**MAJOR PROJECT- MP06_0101 MOD & MP11_0093
Pemulwuy Mixed Use Development, Redfern
Preferred Project Report**

RailCorp has also reviewed the Preferred Project Report (PPR) and provides the following comments. RailCorp notes that Page 2 of the PPR report and Page 1 of Appendix 1 makes reference to this future ownership of the bridge. RailCorp advises that any bridge works and future ownership, care and control of the bridge will be subject to final RailCorp approval.

JOB No.	DE/20210
DATE	October 2010
SCALE	A1 @ As Indicated
DWG No.	3DA200 E

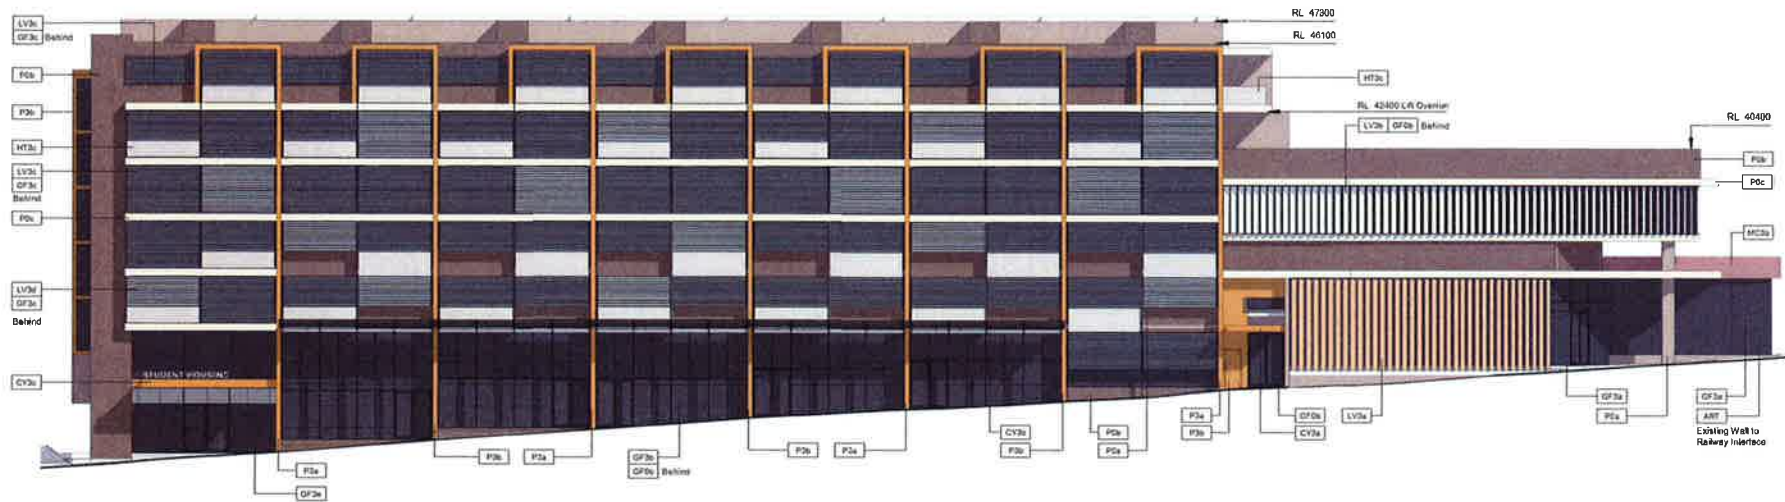
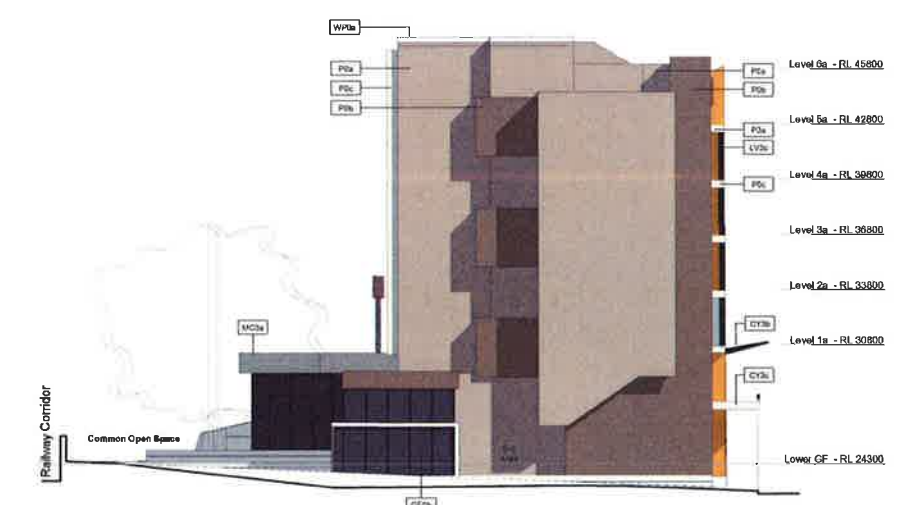
RailCorp also notes that drawing 3DA200(E) now incorporates balconies and roof terraces that were not previously proposed. As such RailCorp needs to ensure that appropriate safety mechanisms are in place to protect the rail corridor and train services from any objects being thrown onto the rail corridor.

- *Given the possible likelihood of objects being dropped or thrown onto the rail corridor from balconies, windows and other external features (eg roof terraces and external fire escapes) from Precinct 3 that are within 20m and face the rail corridor, the Proponent is required to install measures (eg awning windows, louvres, enclosed balconies etc) which prevent the throwing of objects onto the rail corridor.*
